**CITY OF PORTLAND, MAINE
DEVELOPMENT REVIEW APPLICATION
PLANNING DEPARTMENT PROCESSING FORM
DRC Copy**

2006-0118
Application I. D. Number

Lot 6 Willow Knoll
Project Name/Description

Approval Conditions of DRC

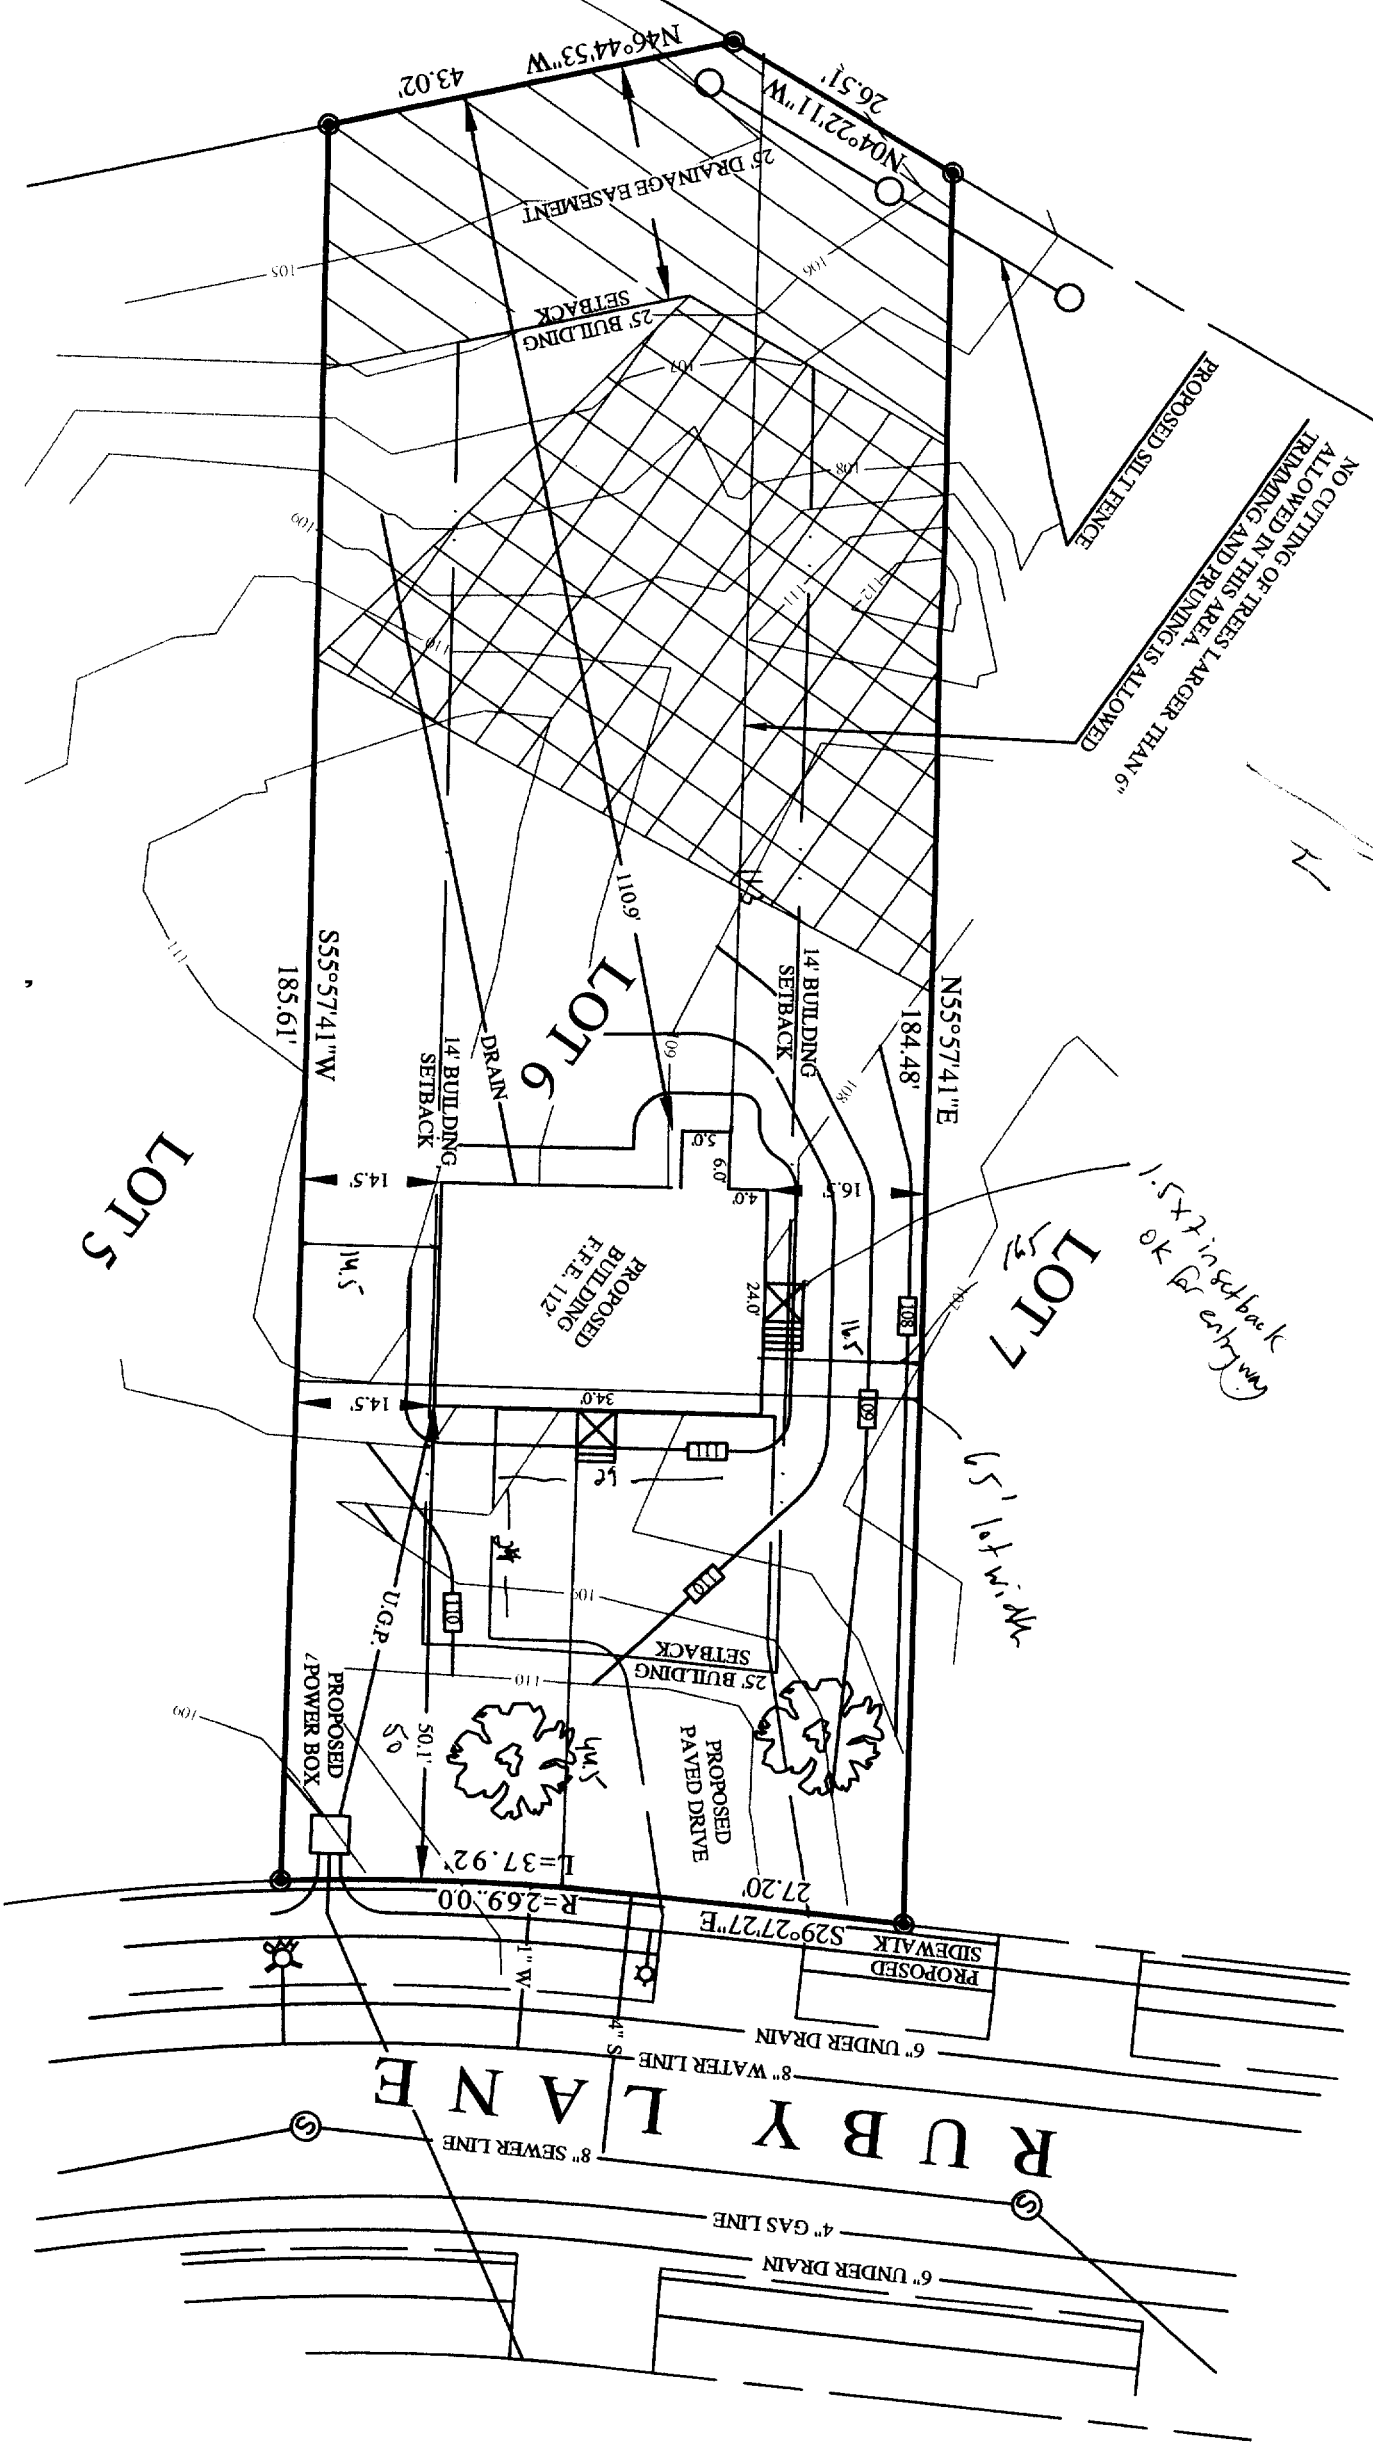
- 1 Silt fence location shall be moved from where it's shown on the plan. Acceptable location is between the new house and the no-cut zone (not behind the no-cut zone).

- 2 Builders shall minimize the amount of tree disturbance when installing the foundation drain in the back yard.
- 3 All Site work (final grading, landscaping, loam and seed) must be completed prior to issuance of a certificate of occupancy.
